Current Zoning: I-2 (General Industrial)
Proposed Zoning: UR-2(CD) (Urban Residential, Conditional), MUDD(CD)
(Mixed Use Development District, Conditional)

Approximately 7.41 acres located on the north side of W Trade Street near the intersection with Wells Meadow Drive.

The petition proposes to redevelop a site currently occupied by a childcare center with up to 116 single family attached residential dwellings and 12,000 square feet of non-residential uses.

PLANNING STAFF REVIEW

SHEET NUMBER **RZ-02**

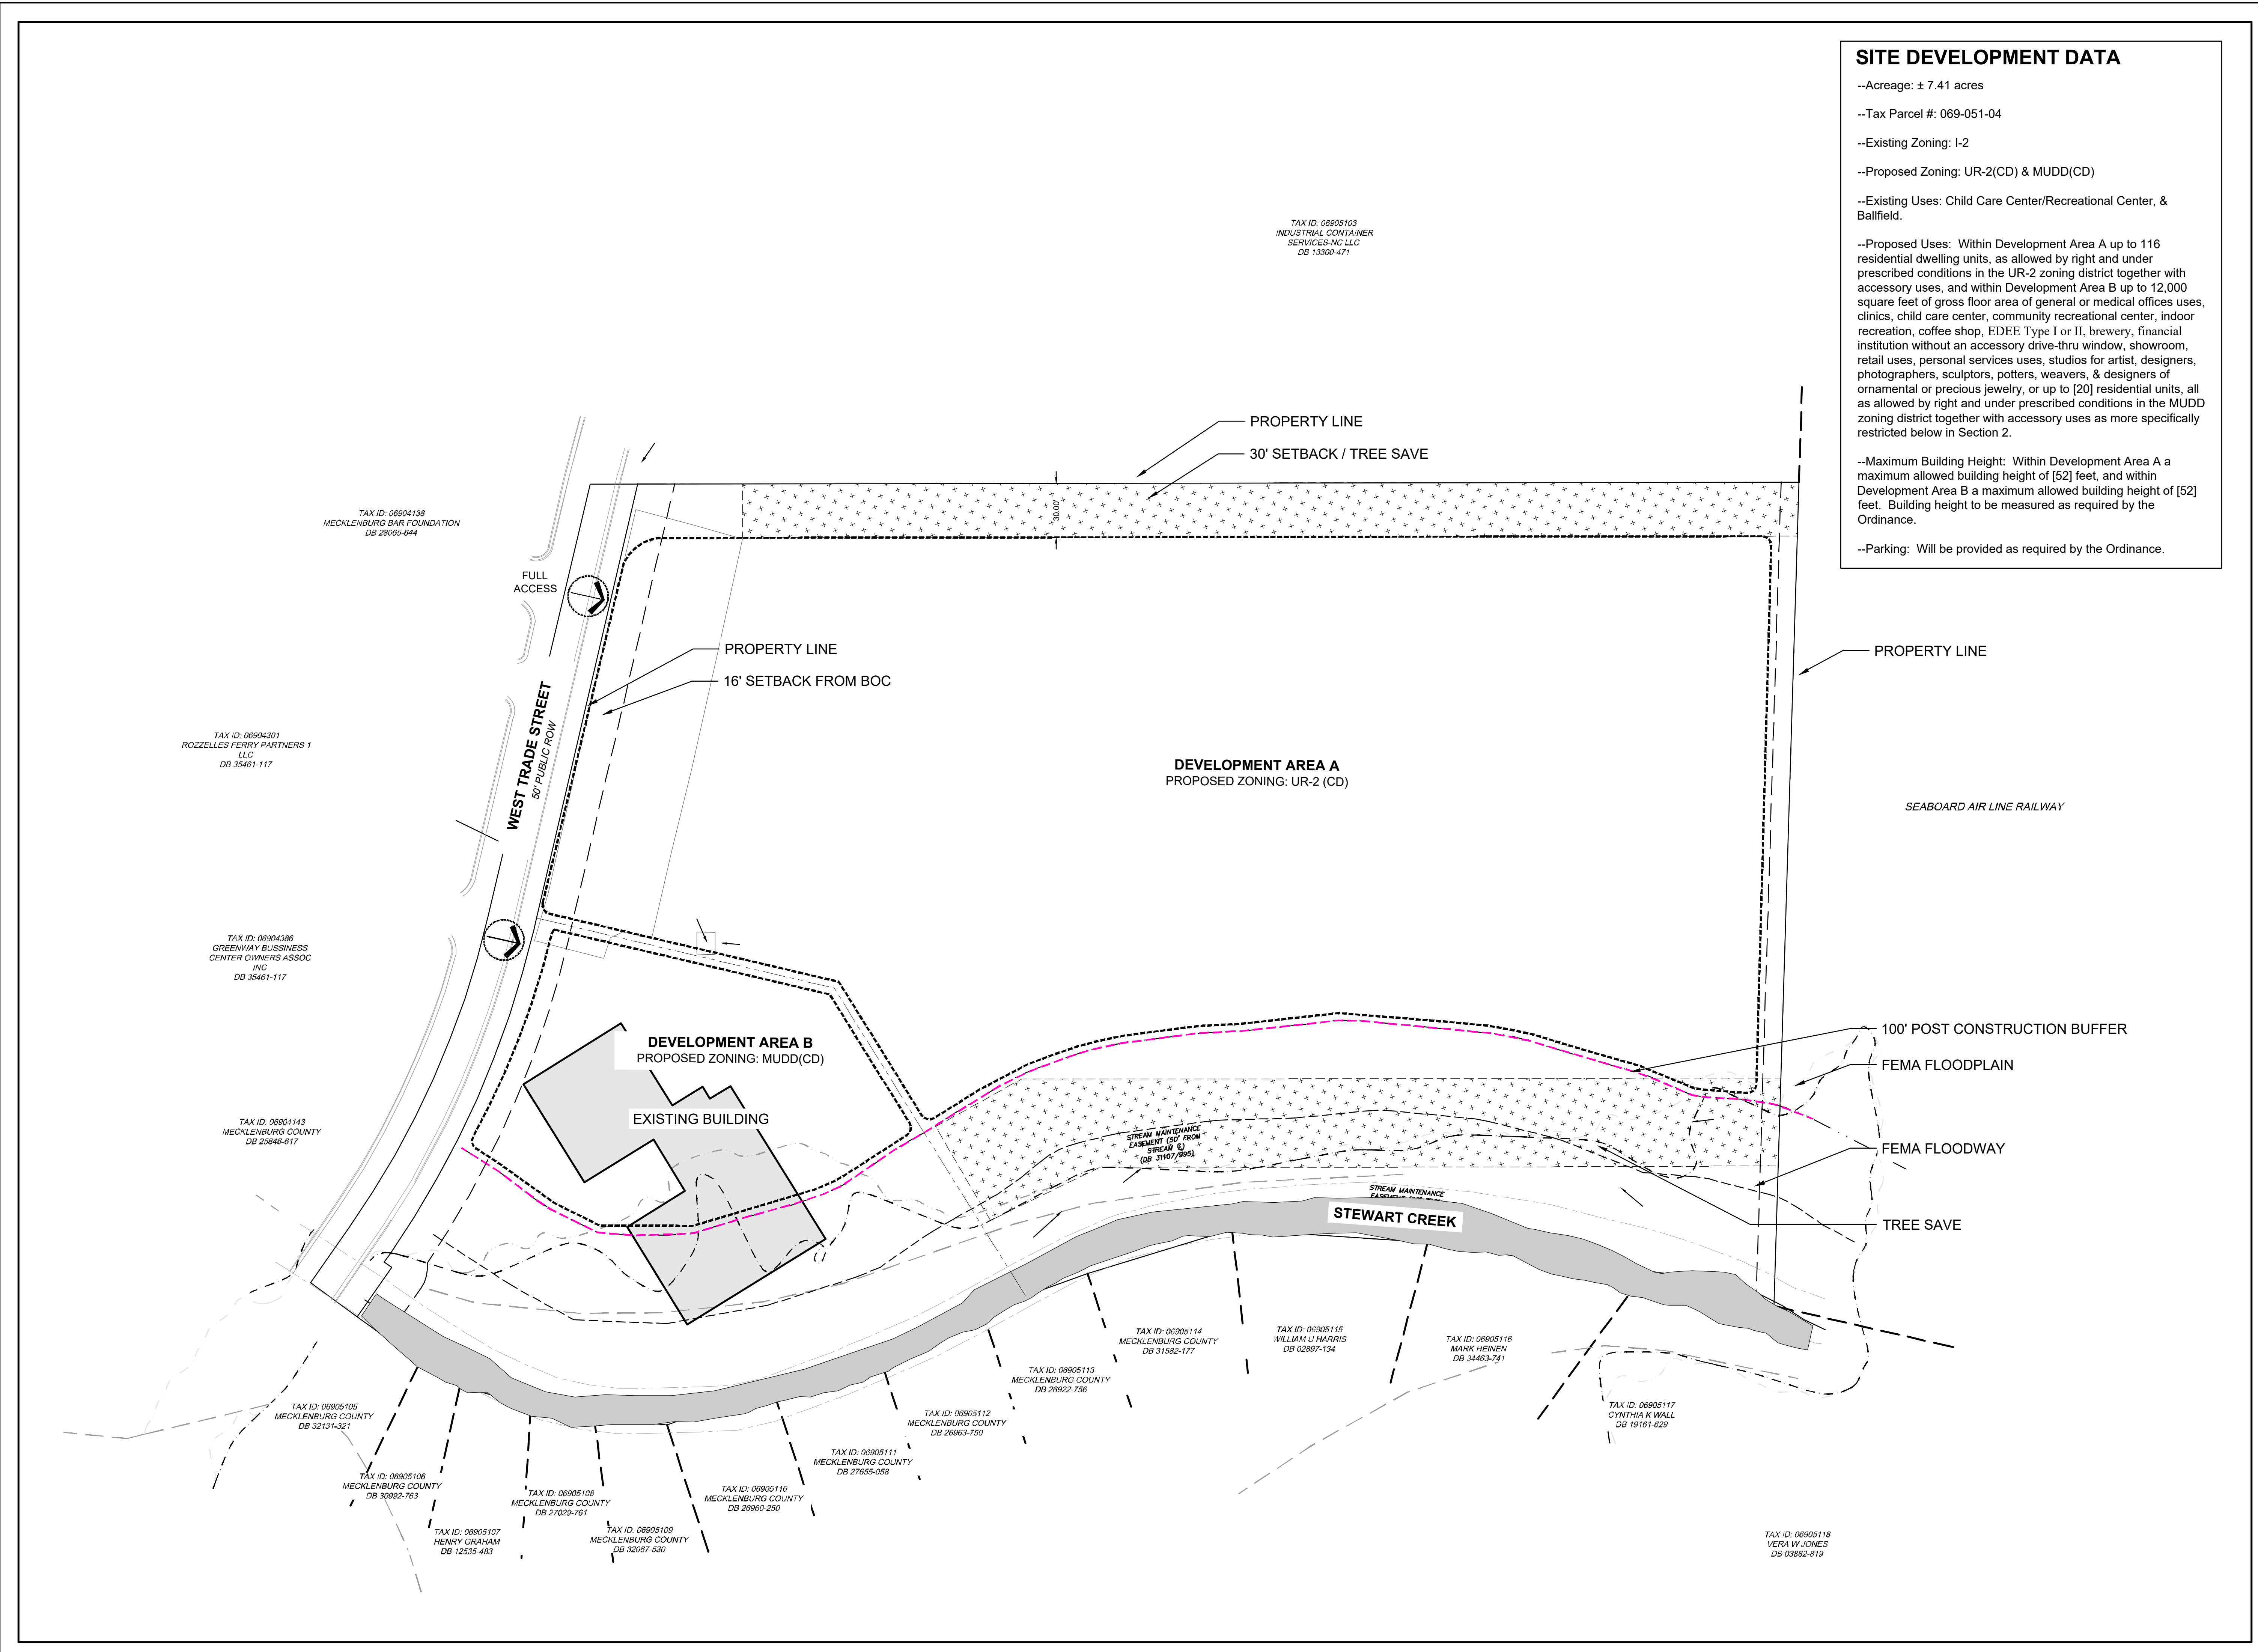
1. Revise the site plan to show a 100' greenway easement dedication except where the building is located within the SWIM buffer.
2. Revise the site plan to include an easement between the 100' greenway easement and internal sidewalk network.
3. Wrap internal sidewalk around the northeastern most building to improve connection to open space.
4. Remove note 4.c regarding side and rear yards.
5. Clarify note 7.a regarding the provision of urban common open space and private open space.

6. Clarify note 5.c regarding the front elevation of each dwelling unit.
7. Commit to preserving a minimum of 25' along the western property boundary as tree save or label as a 25' Class A buffer.
8. Reword note 2.b to state that Development Area B may include up to 12,000 square feet of gross floor area of noted uses within the existing building.
9. Reword note 2.c to state that any Type II EDEE use must serve food.
